CITY OF ALBUQUERQUE

February 26, 2015

RE: **Chick-fil-A**
1600 Gibson Blvd SE
Grading and Drainage Plan
Engineers Stamp Date 12/15/14 (M15-D012C)

Based upon the information provided in your submittal received 2/23/2015, the above referenced Grading and Drainage Plan cannot be approved for Grading Permit or Building Permit until the following comments are addressed.

C-3.0

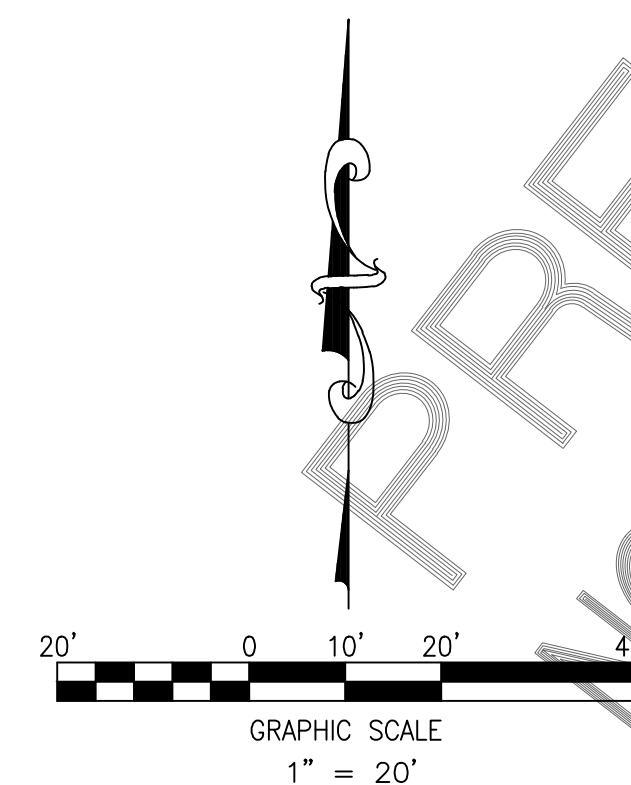
- Provide the legal description on the G&D plan along with the benchmark location.
- Show the roof flows.
- Depress all landscape areas which are no closer than 10 feet from the building. Create a curb opening on the high side of the parking lot island's and let the flows overtop the curb on the low side.

- The plan would be easier to review if sheets C-3.0 & C-3.1 or provide build notes on sheet C-3.0 to get rid of Sheet C-3.1. The storm plan can also be added to sheet C-3.0 and the profiles can be reduced and added to the basin map. Sheet C-3.3 can be deleted if references to these profiles are made on the sheet C-3.0. Also, when time comes to submit for Certificate of Occupancy, fewer sheets will need to be certified.
- Basin B-1 needs to flow through a first flush retention pond before leaving the site.
- What is the purpose of storm drain line B?
- There appears to be a ponding area in the drive up lane.
- An SO-19 permit may be required, depending on if the stub from Gibson Blvd. was extended/built into this site.

Sheet
C-3.0

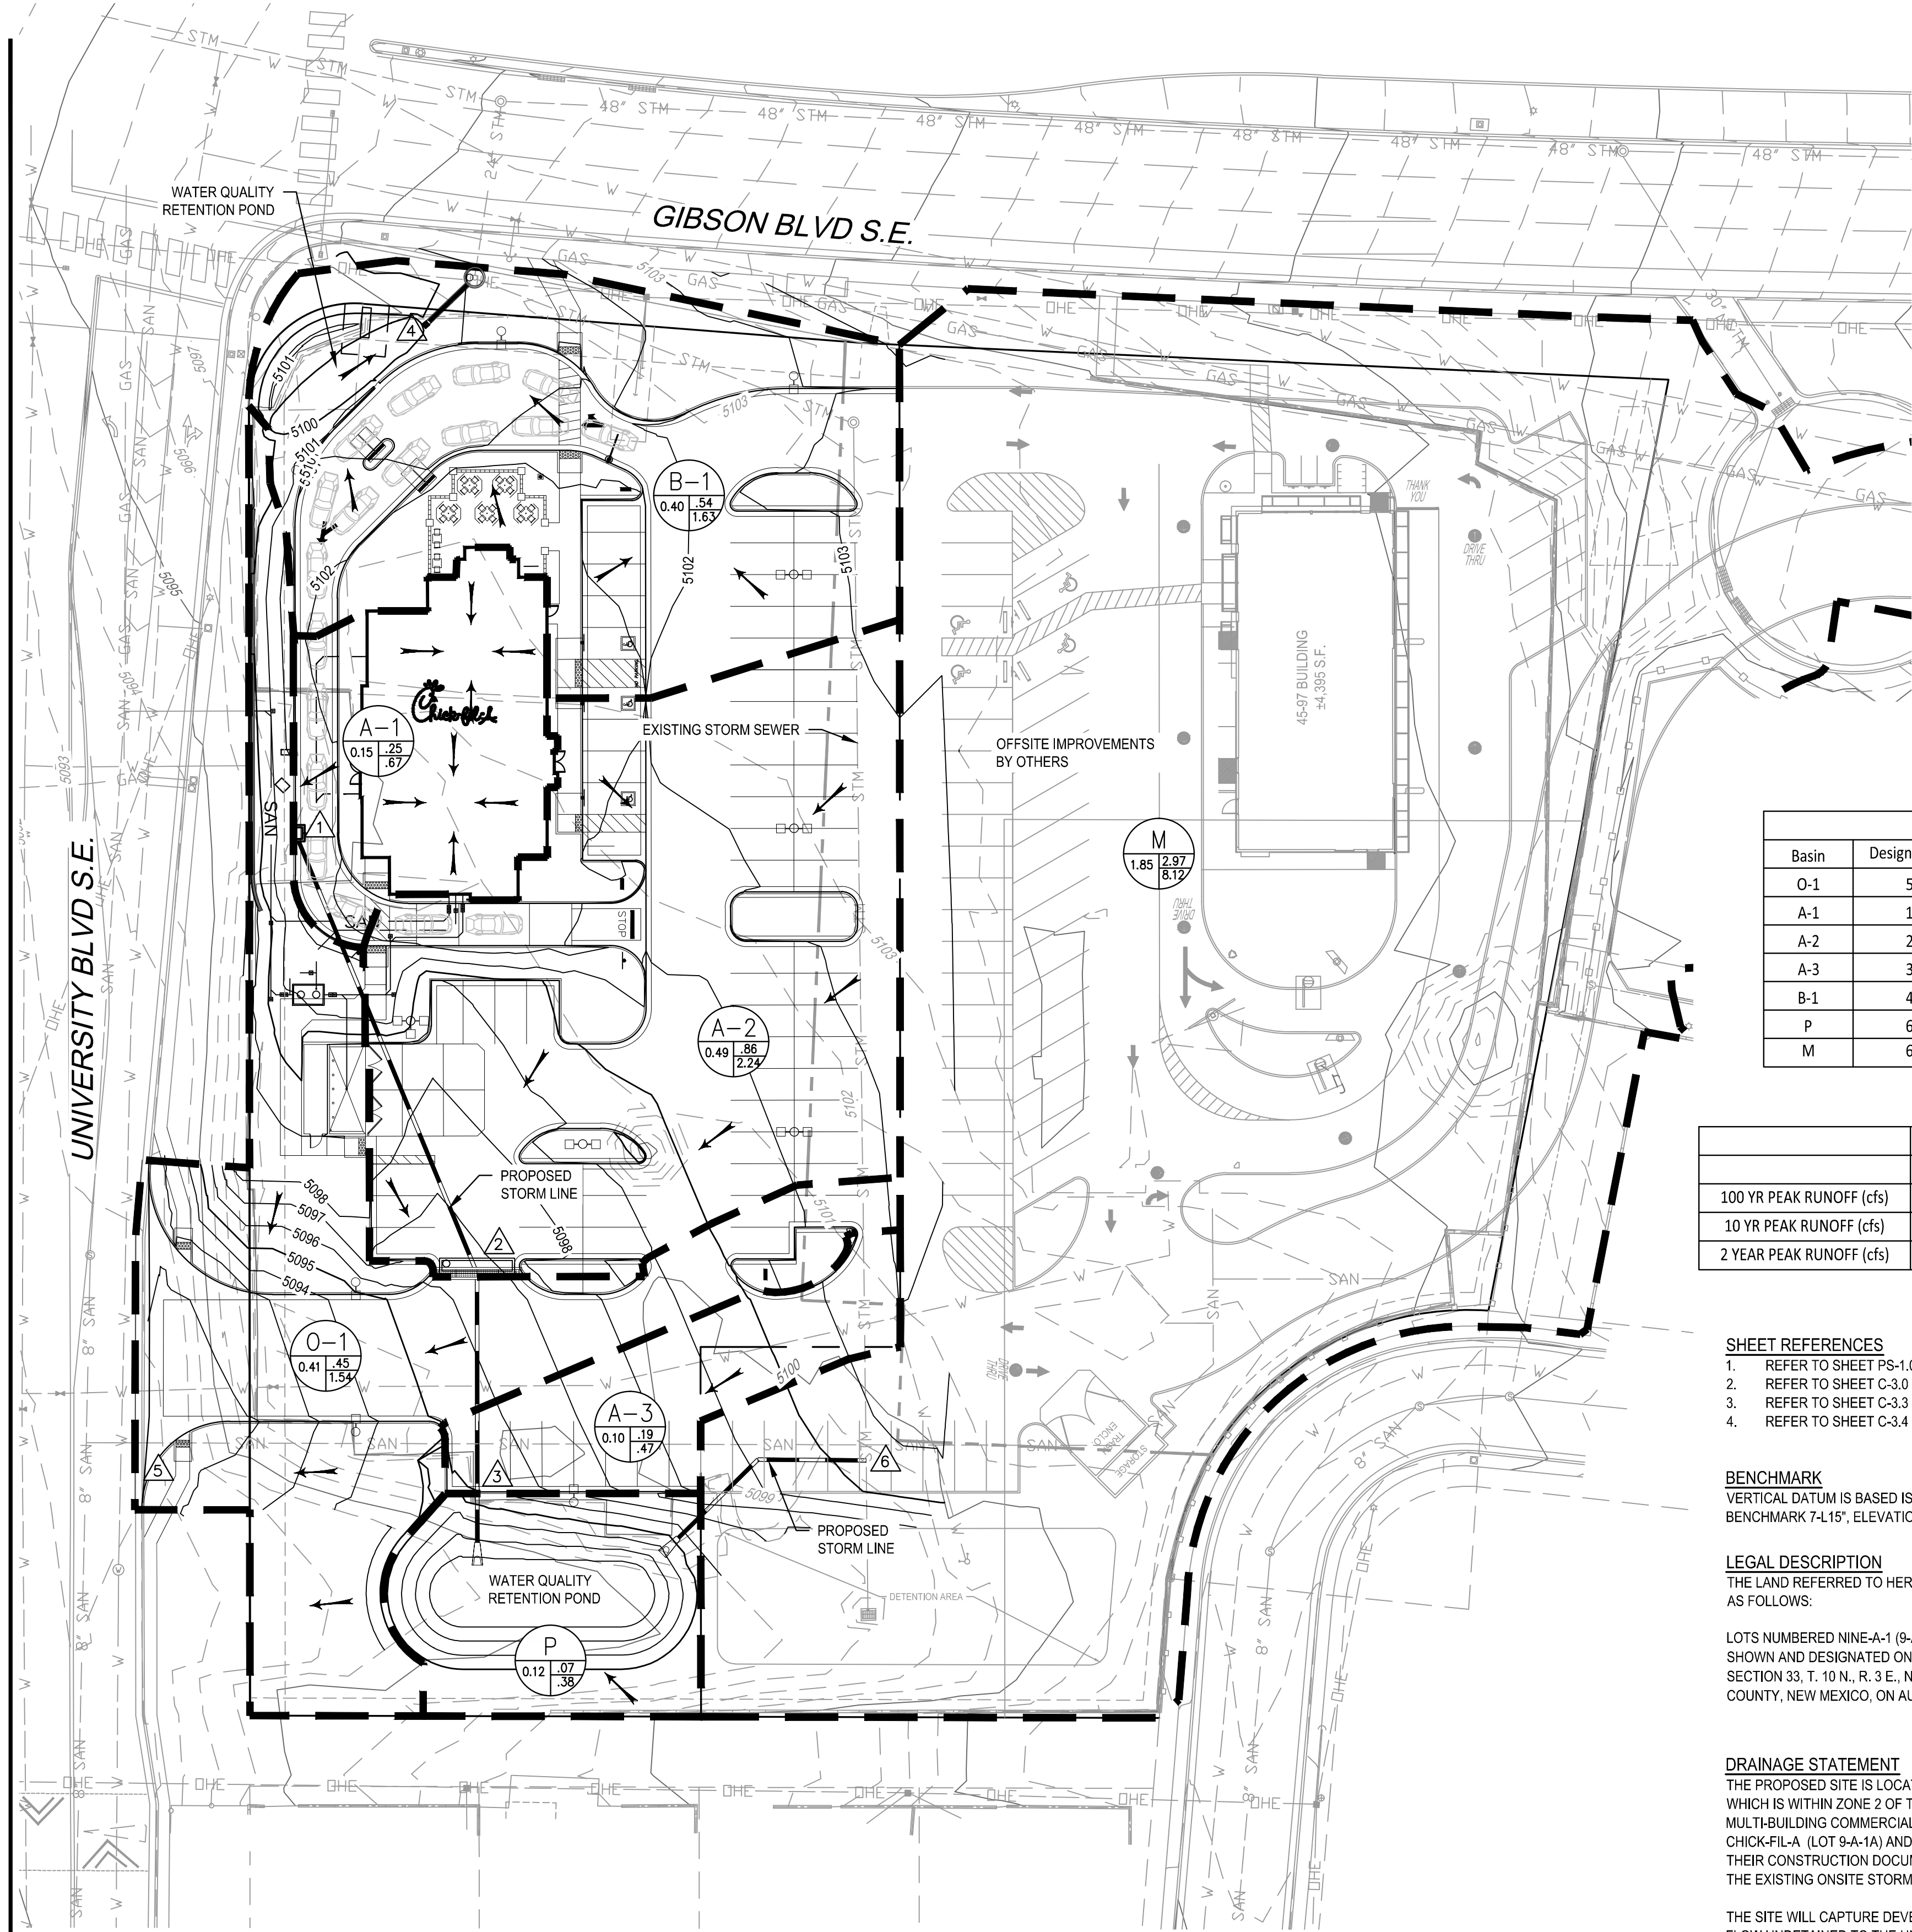
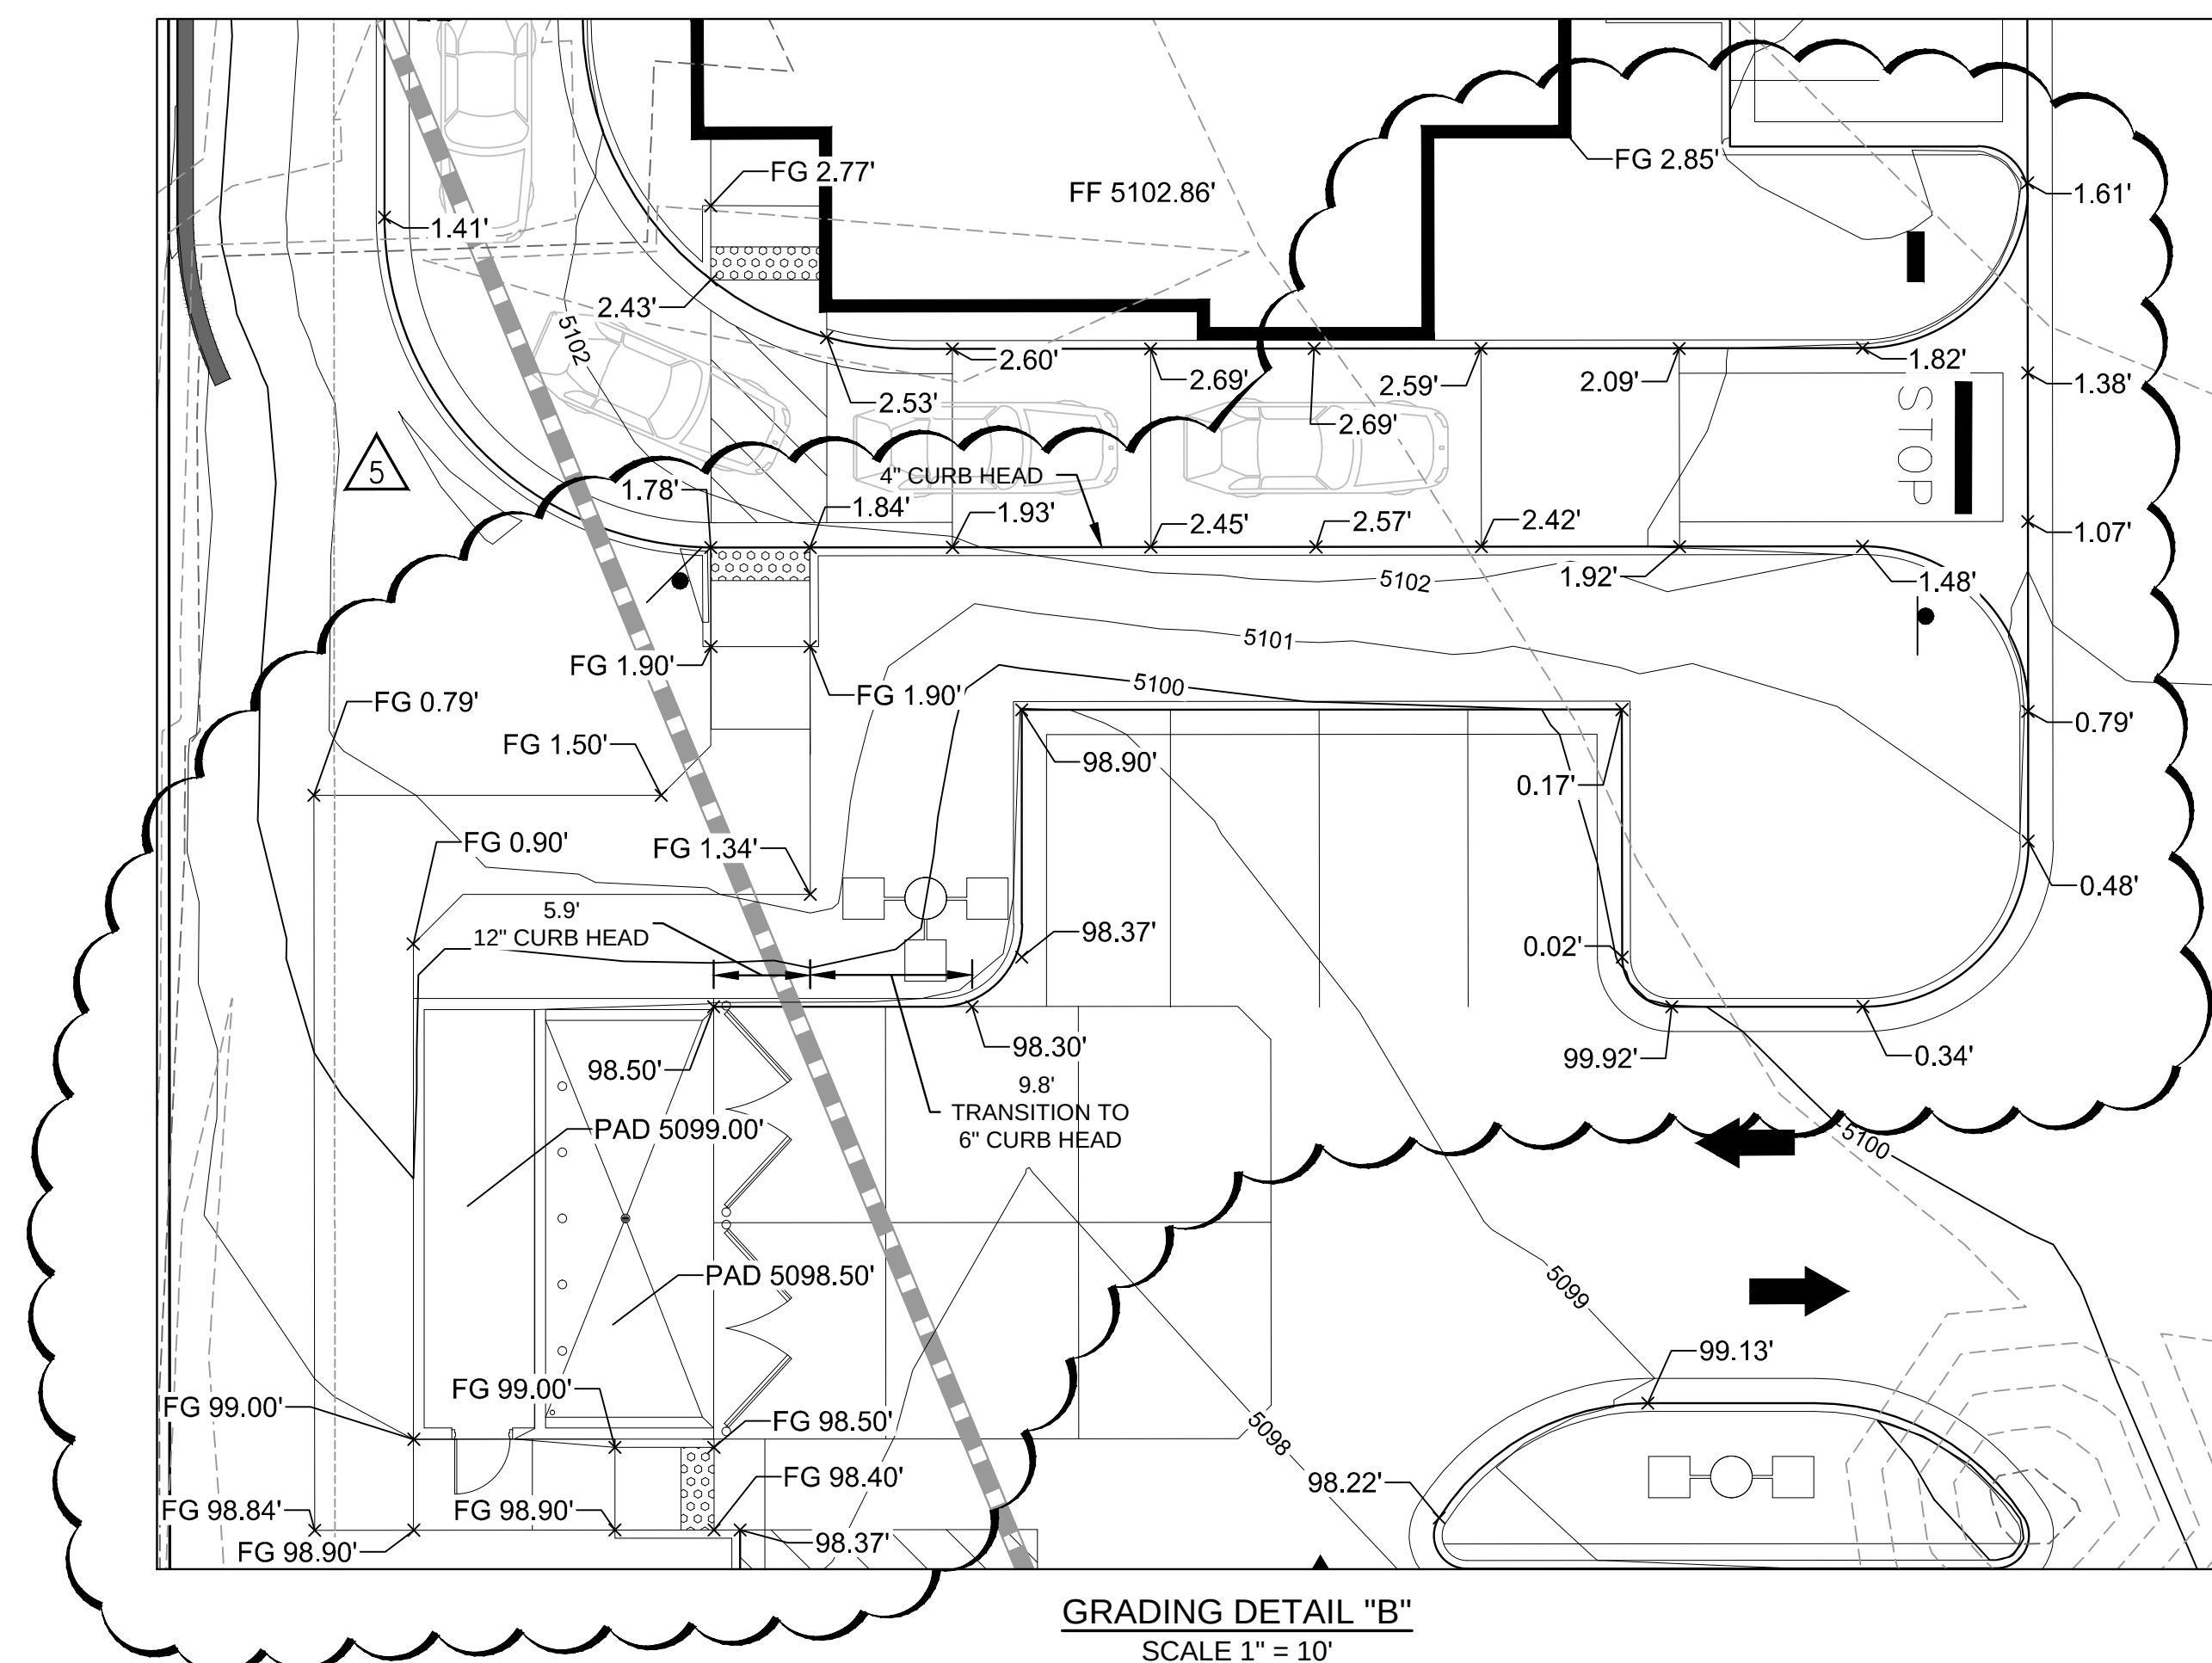
- All flows are to enter University Boulevard's storm drain system, only 0.8cfs is allowed to surface flow onto University Blvd.
- Provide the vicinity map for the area. Also provide the FIRMette or mention the flood zone and map page.
